March 25, 2024

Reference: Engineering Services
Smith Garage
Project No.: DRB2301-0387-A

1. Stem wall foundation in-lieu of the plan specified monolithic slab.

FOUNDATION PLAN

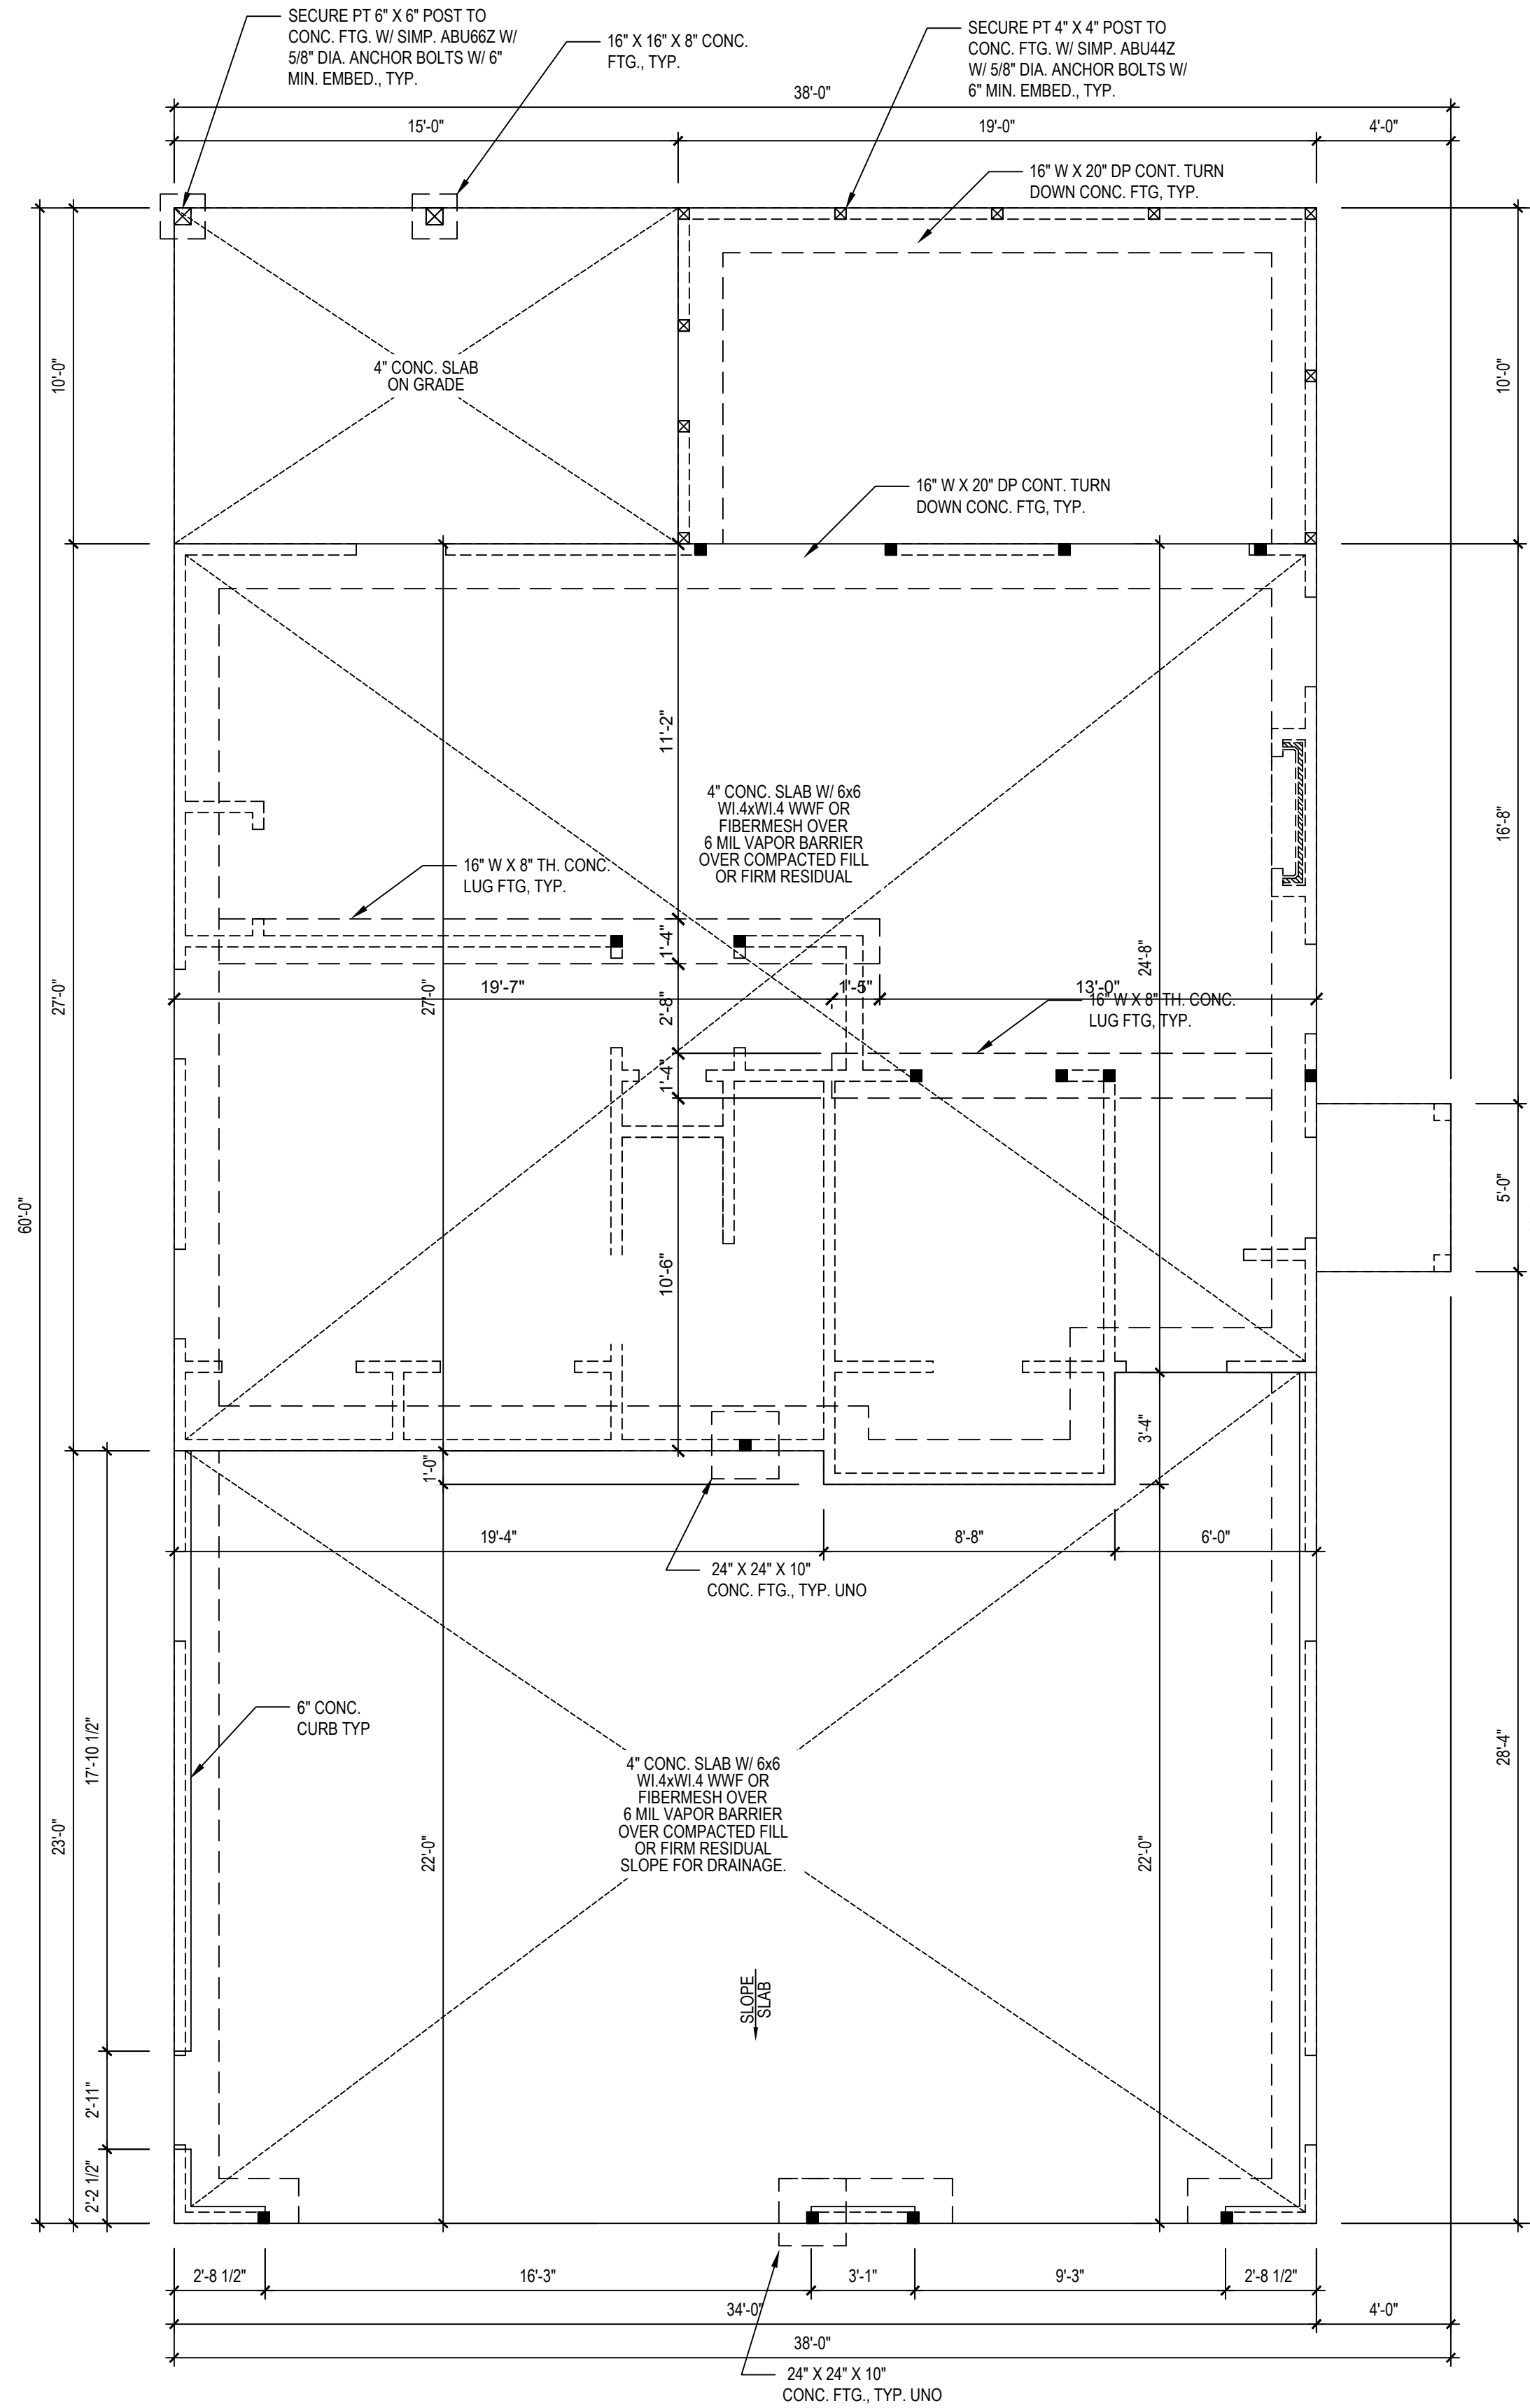
1. Based on our plan review and analysis, the proposed stem wall foundation should be constructed in general accordance with the attached diagrams on sheet 2 and 3 of this report.
